From: East Preston Parish Council
Sent: 31 March 2011 14:07
To: Anita Gardner
Subject: EP/16/11

At its meeting held on Monday, 28th March 2011, the Planning Committee of this council agreed unanimously to comment on this Application as follows.

The Council has major concerns about this Application, and wishes to OBJECT on the following grounds:

drawing: Roof Plan

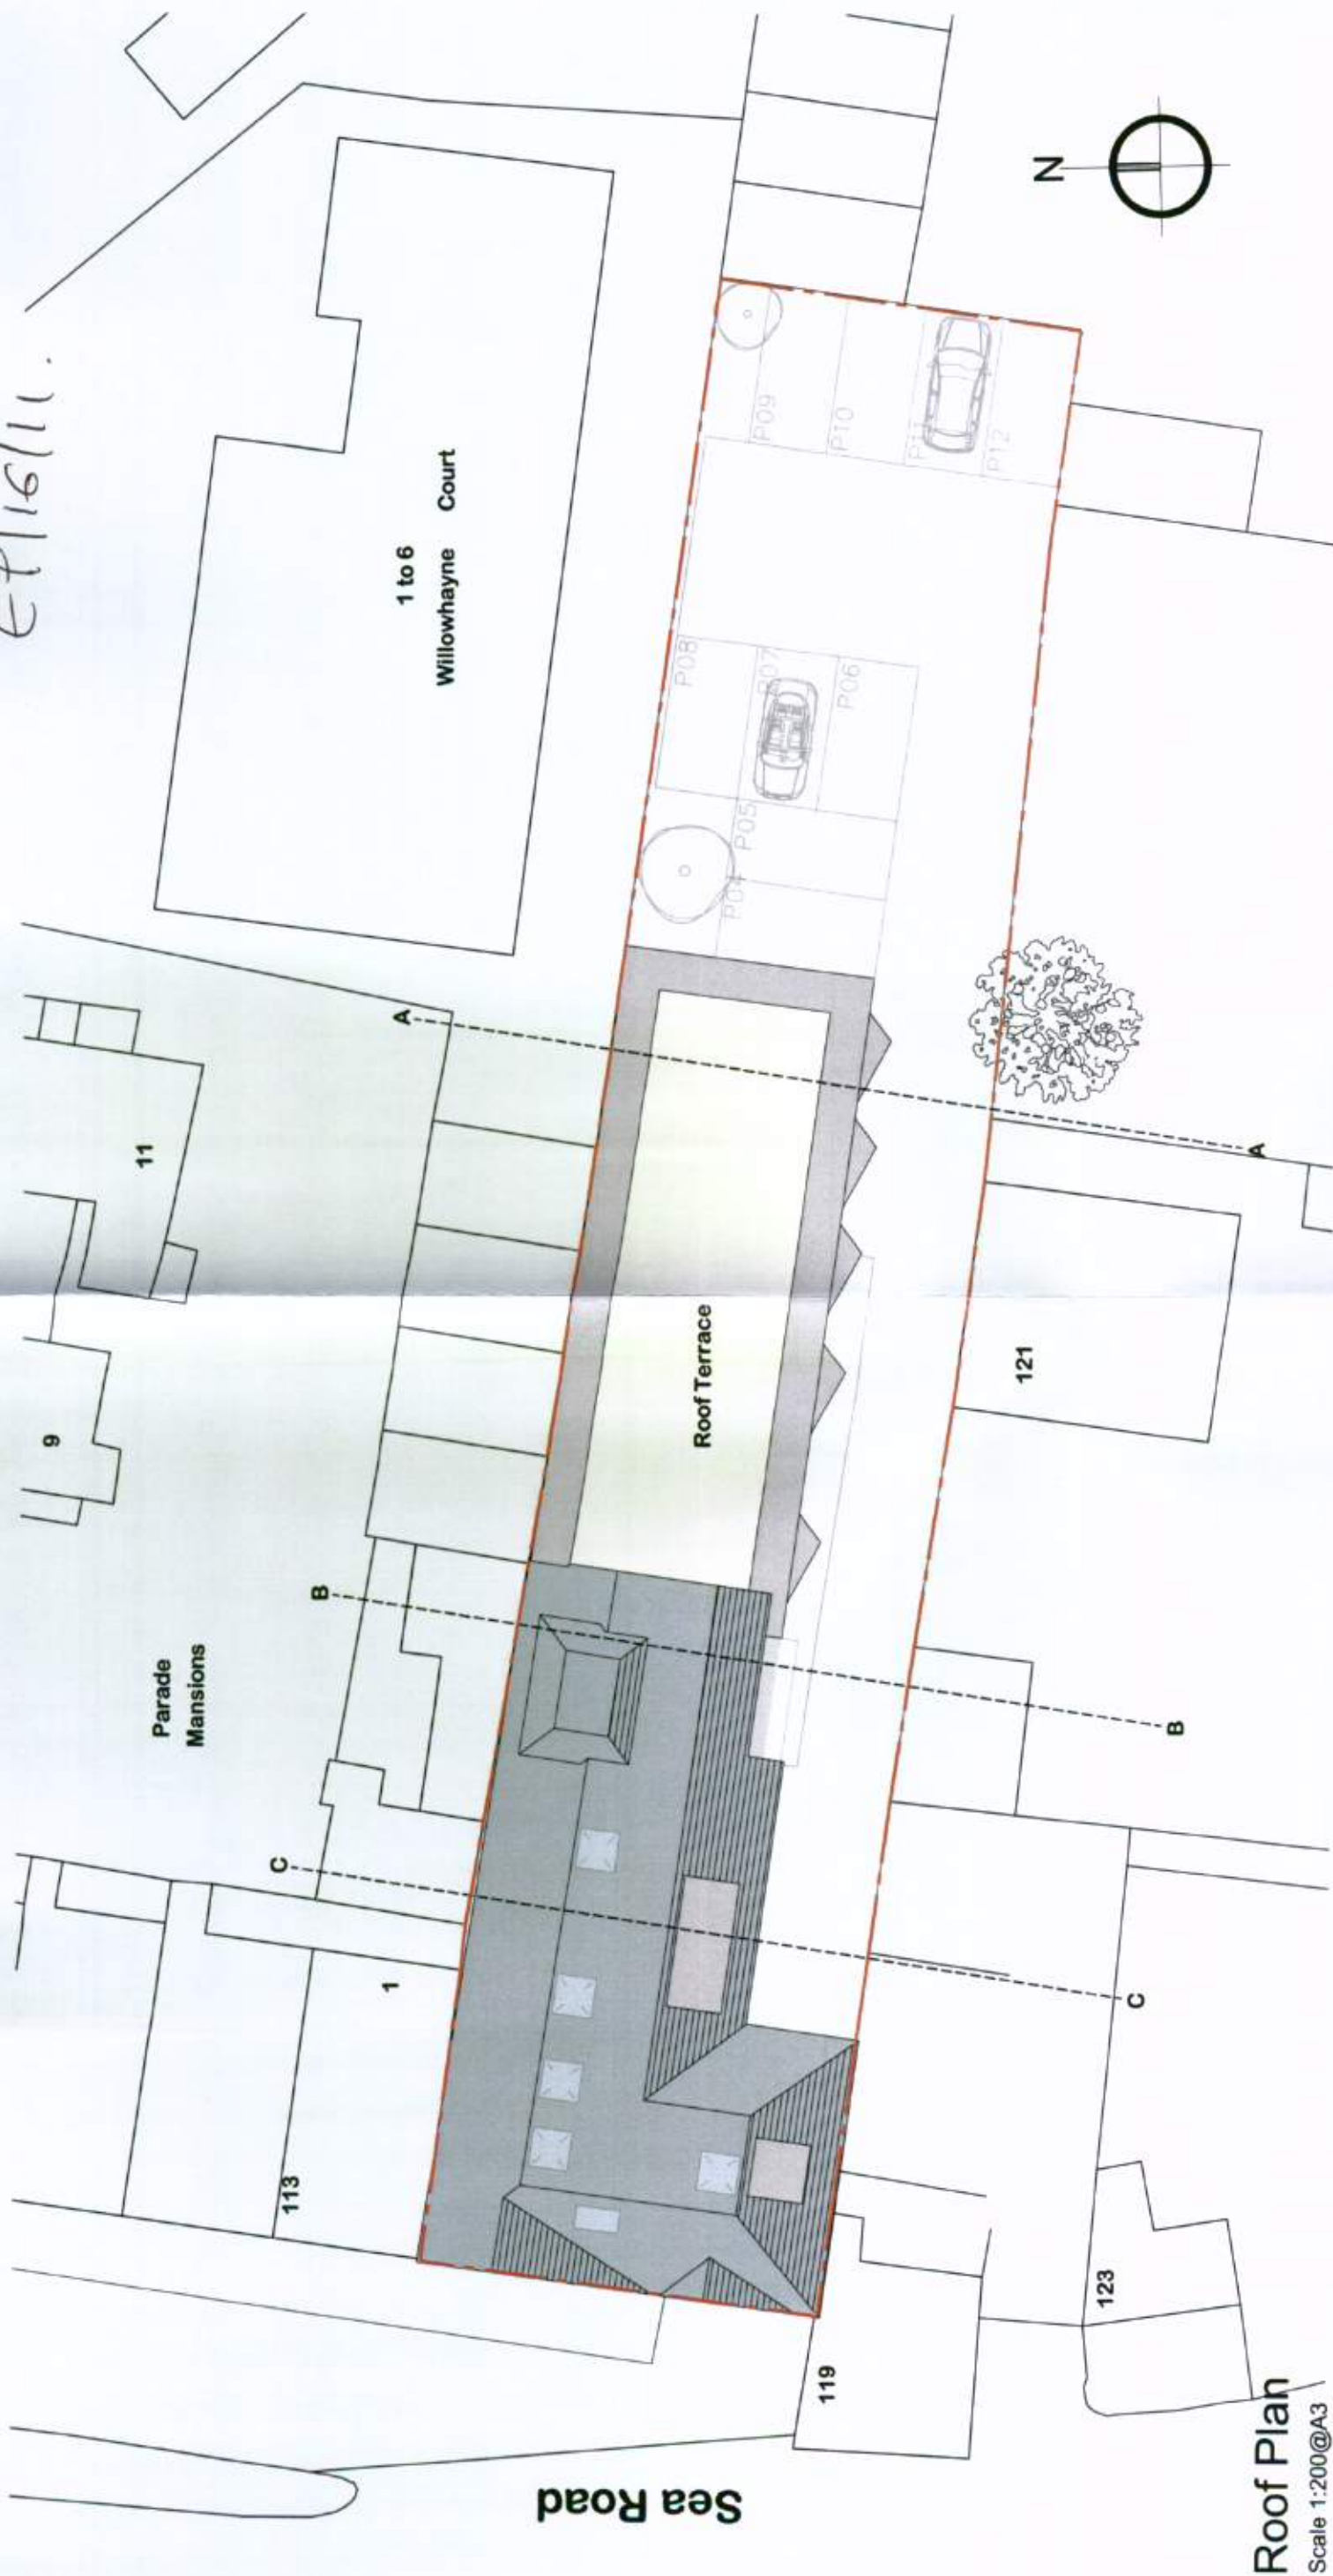
4. The proposed design of the higher level windows facing south would not solve the problem of overlooking. The design of the amenity space at roof level would be insufficient to protect the privacy of residents and prevent overlooking of adjacent properties. The proposed development has an unacceptable adverse impact on adjoining occupiers and therefore again conflicts with Policy GEN7 of the Local Plan.

North & East Elevations

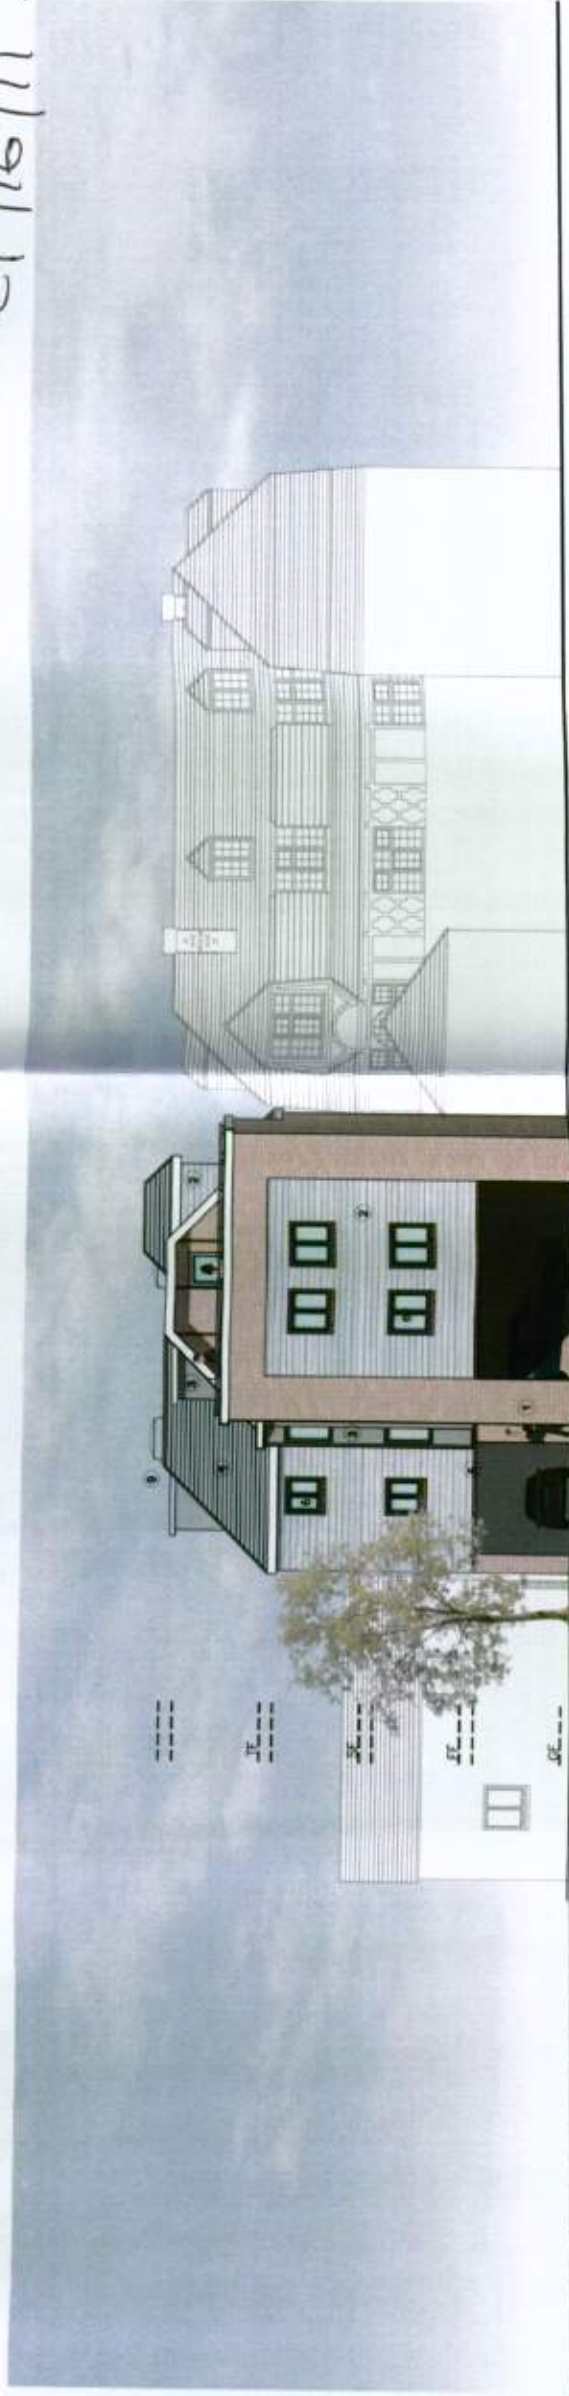
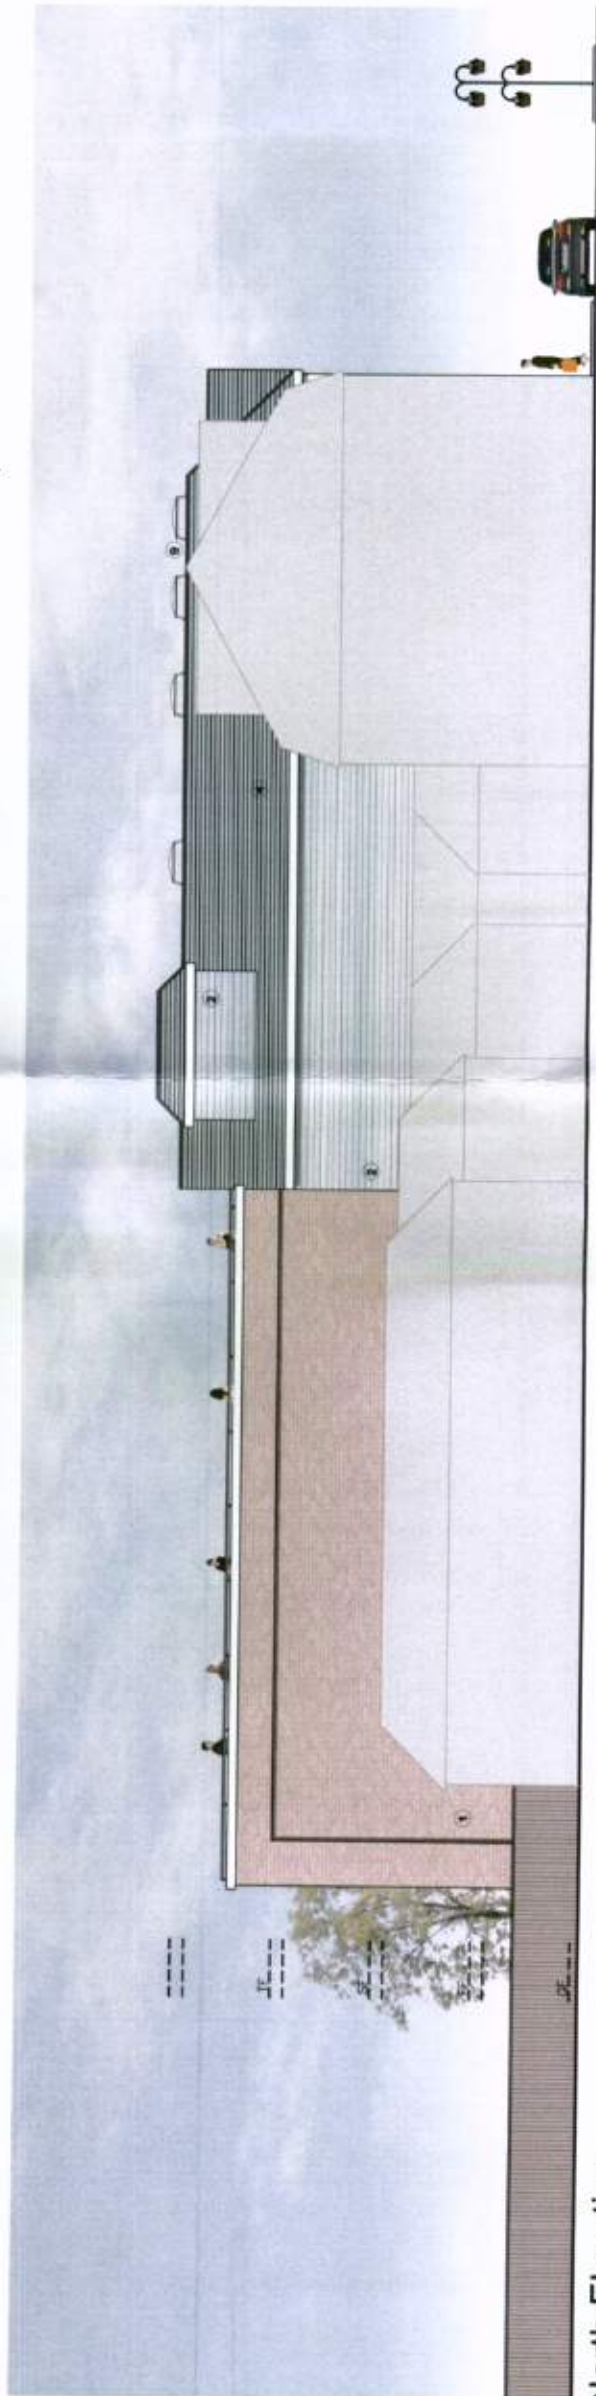
1. The design of the building is inappropriate for its immediate surroundings and does not harmonise with the existing traditional buildings in this parade of shops and the residential accommodation above. Parade Mansions in East Preston's southern shopping area is located in an area of special sensitivity that deserves protection from unsympathetic development. The proposal is therefore contrary to the provisions of the East Preston Village Design Statement (pages 8 and 15 refer).
2. The proposed development would result in material detriment to the amenities of the occupiers of the neighbouring properties by reason of overshadowing, loss of natural sunlight and its oppressive and overbearing impact. The proposal would thereby detract from the amenities and quiet enjoyment of these properties in conflict with Policy GEN7 of the Arun District Local Plan.

6. The proposed contemporary design and materials would have an unacceptable adverse impact on the adjoining existing Parade Mansions buildings which would adversely affect the street scene, contrary to Policy GEN7 of the Local Plan and to the provisions of the East Preston Village Design Statement.

Section A-A

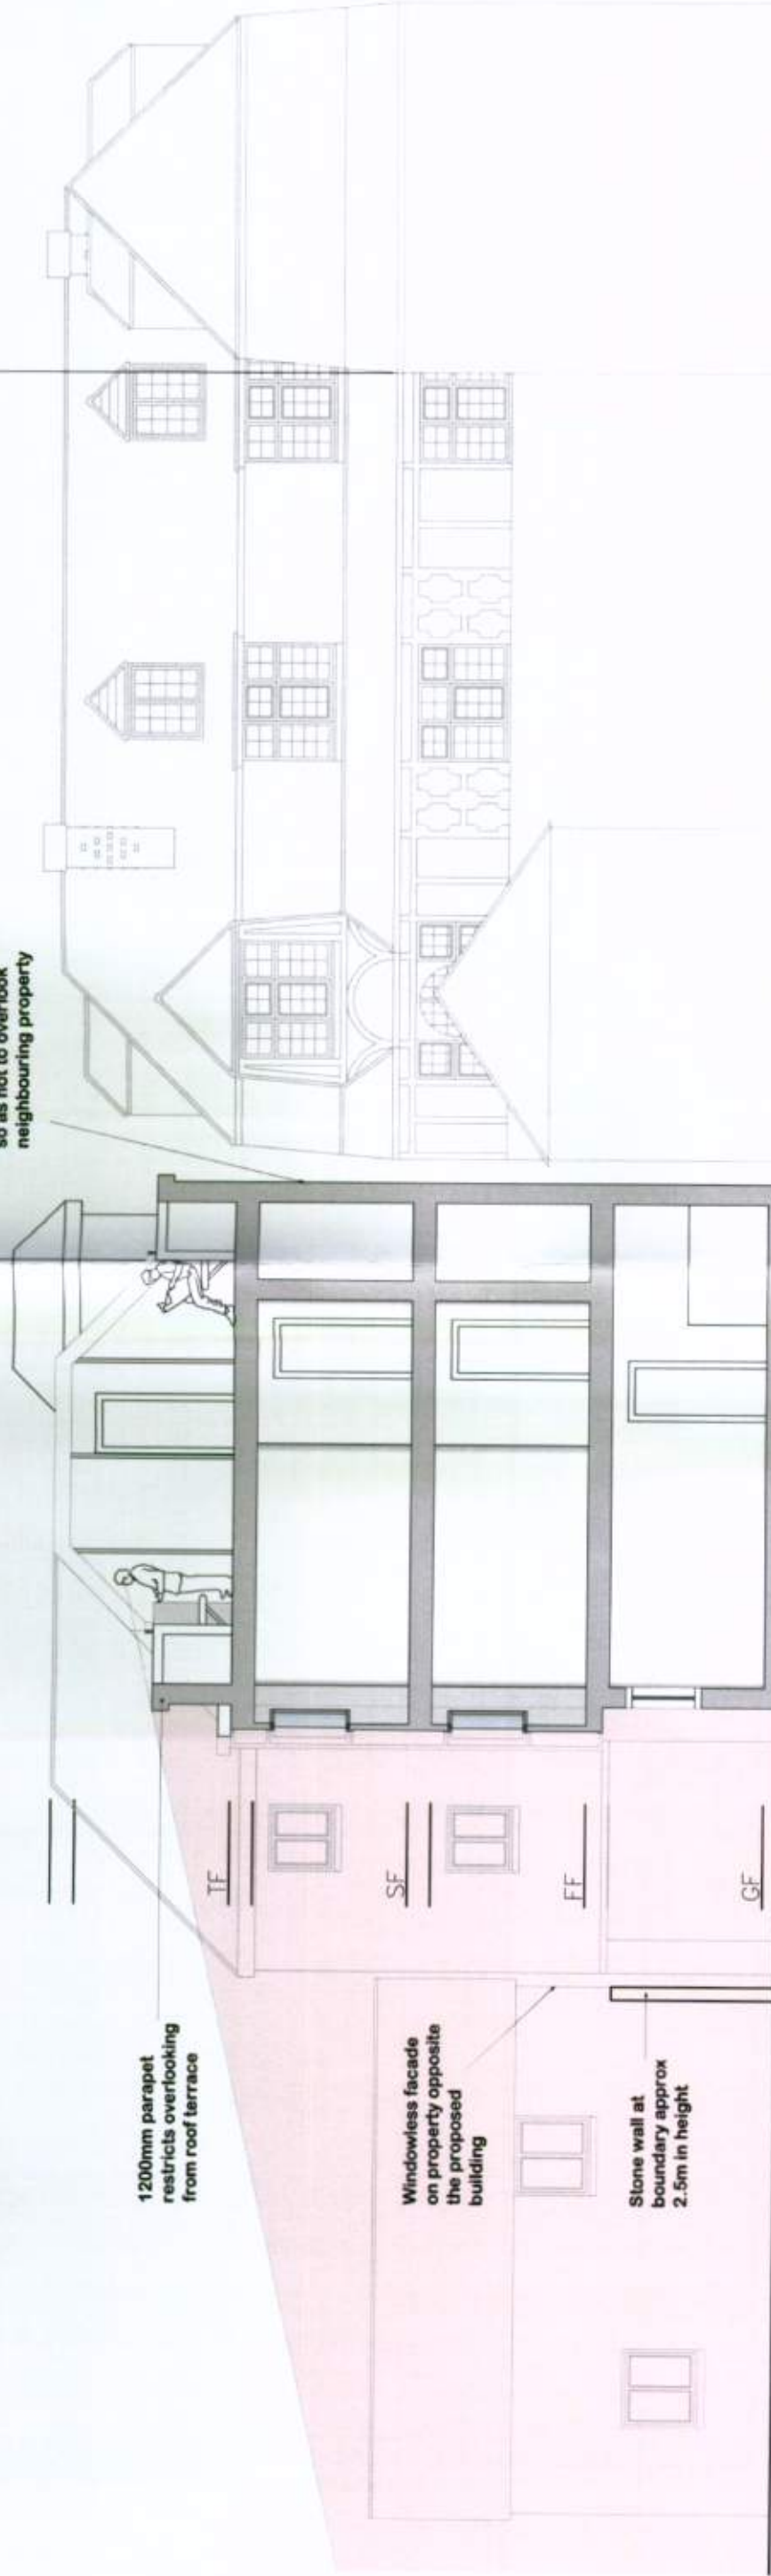
3. The proposal to site the construction of this four storey building on the boundary to abut the single storey shop property, 119 Sea Road, together with the close proximity to the boundary (approximately 3m) and two storey dwelling at 121 Sea Road would be unneighbourly and would result in severe overlooking of the gardens of 121 Sea Road and Coastguard Cottages to the immediate south of the site. The cottages are identified as Buildings of Character and are recognised as contributing to the character and appearance of the area and deserve protection. The proposal would therefore conflict with Policies GEN7 and GEN22 of the Local Plan.
